Project No: 1319

Project Address: 120-122 Smith Street, Wollongong NSW 2500

Re: DESIGN STATEMENT: S4.55 PROPOSED DESIGN MODIFICATIONS TO SSD-67895459

Title:
South Elevation From Communal Space

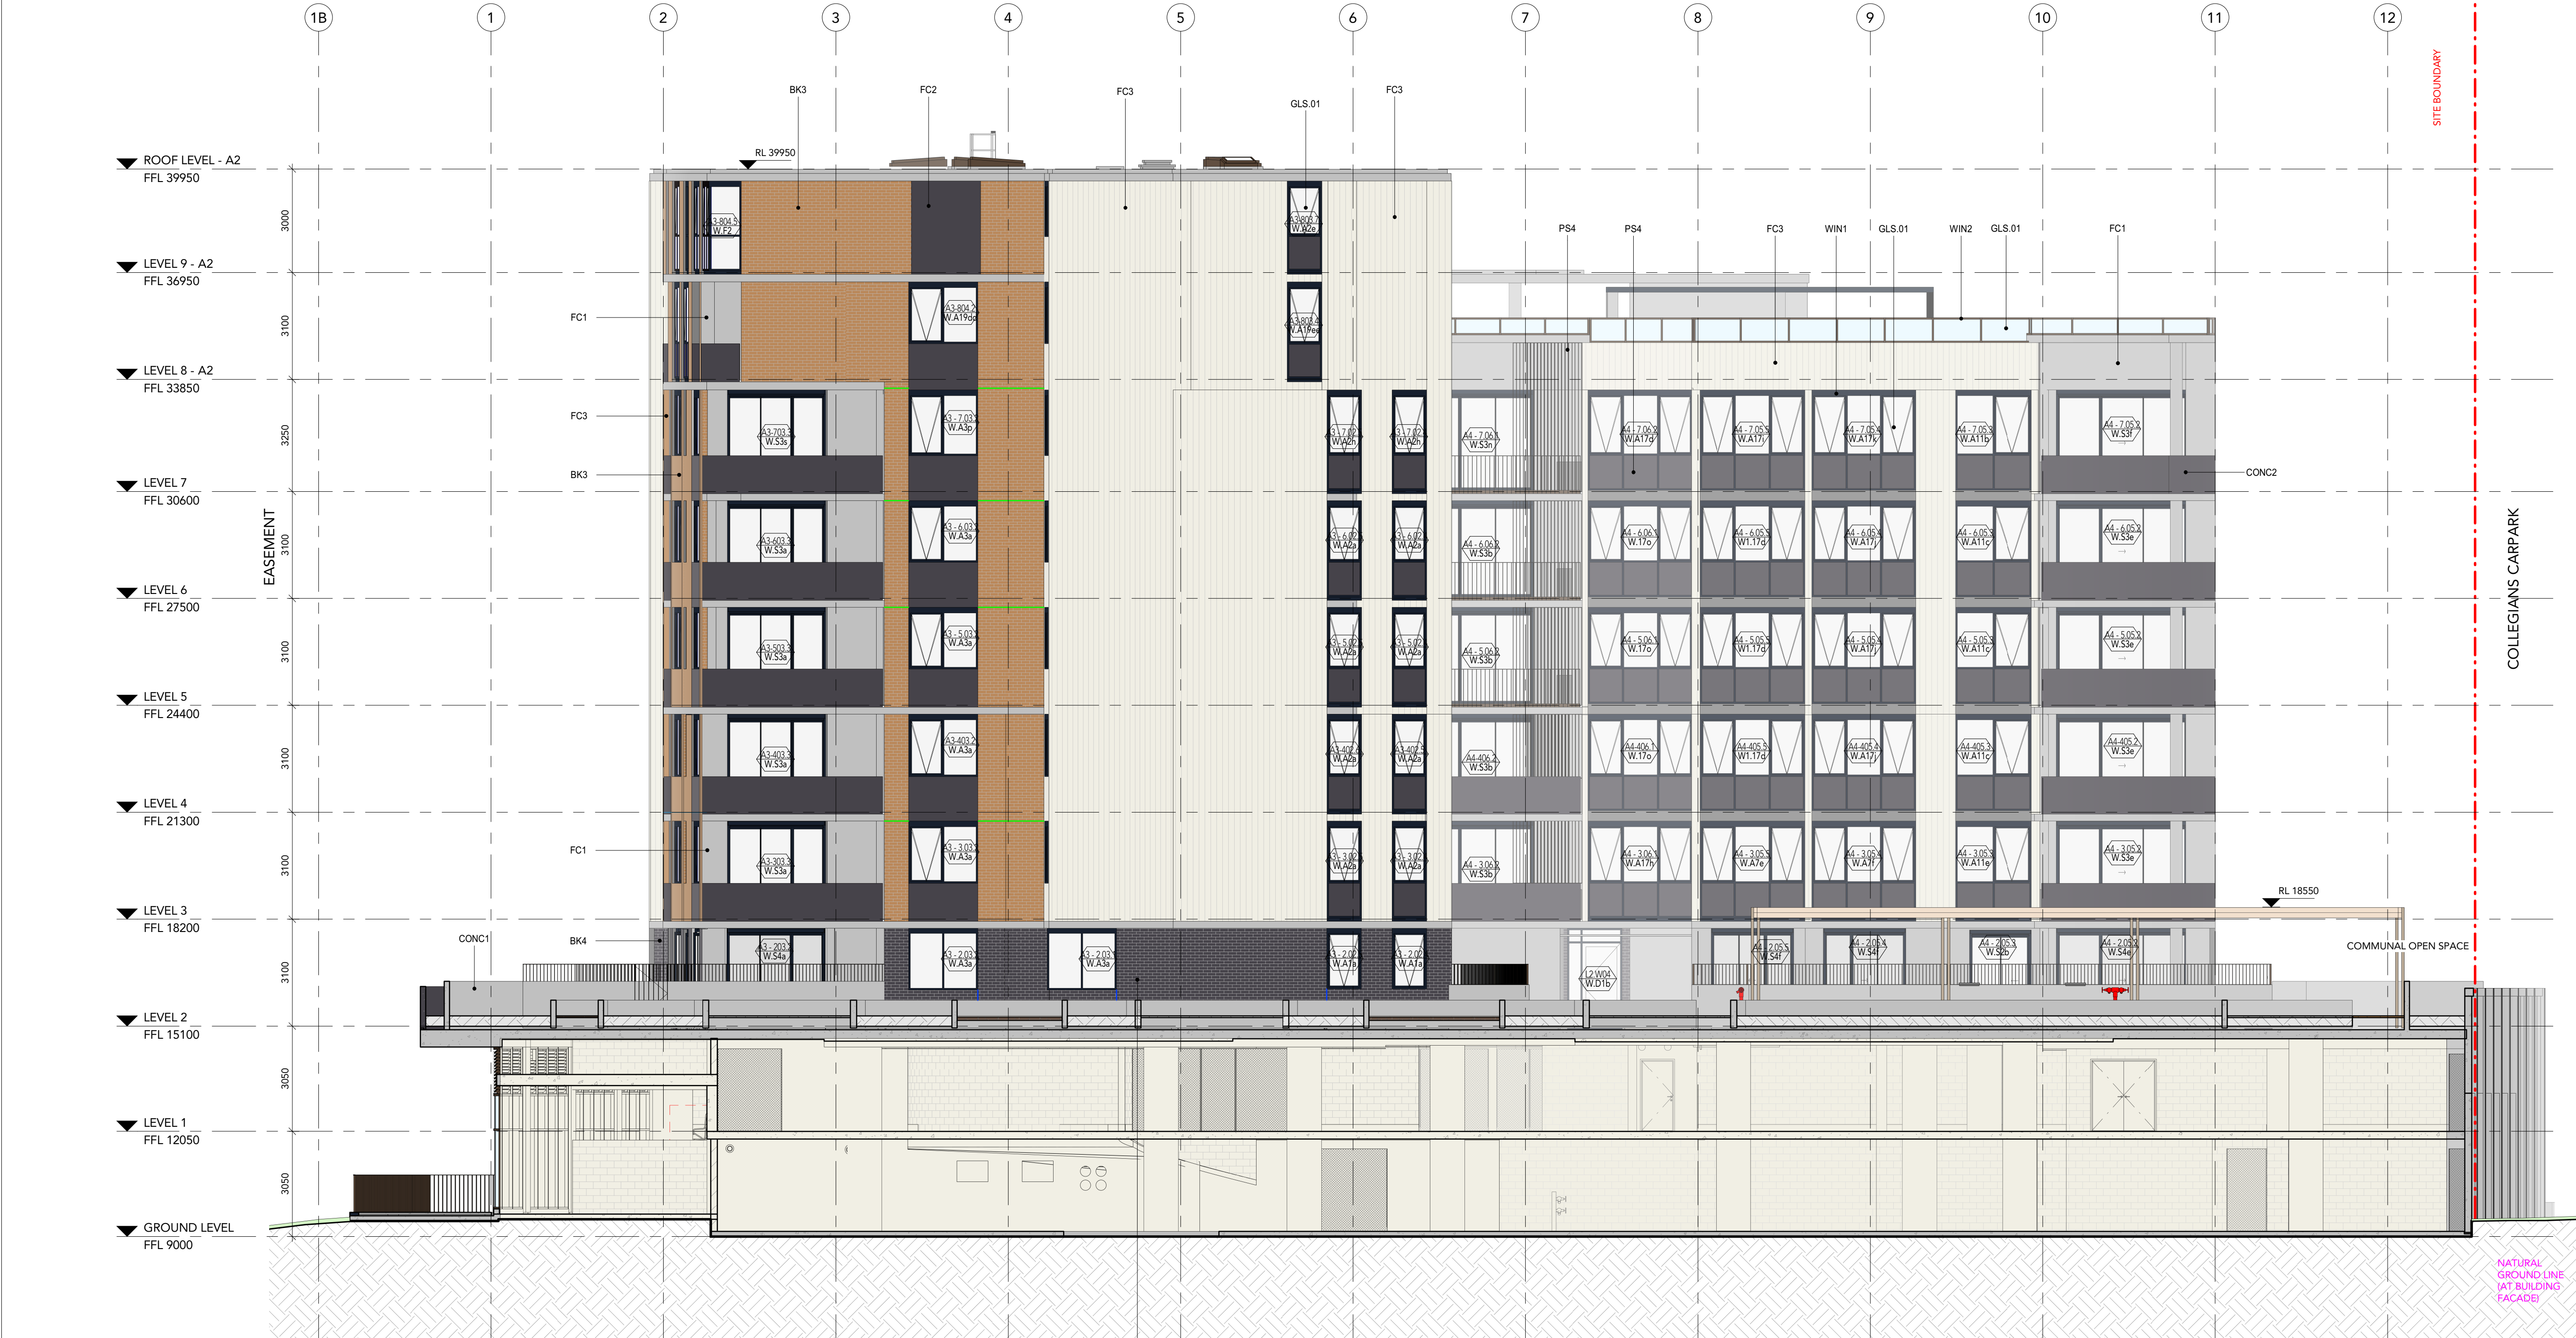
Description of Proposed Modifications	
General Updates	• Amended Façade finishes and Balustrade • Balustrades amended from BAL1 to CONC1 • Balustrades amended from finish FC1 to CONC1 • Addition of Metal capping to the façade • Introduced balustrade materials. • Extent of finishes on the façade • Amended Room Layouts • Amende Riser Layouts • Apartment numbering amended • Entry Doors on Ground floor amended from bi-fold to sliding and fixed glazed • Lift Core names changed
Ground	• Removal of entry doors • Bi-Fold entries amended for fixed glazing and sliding doors.
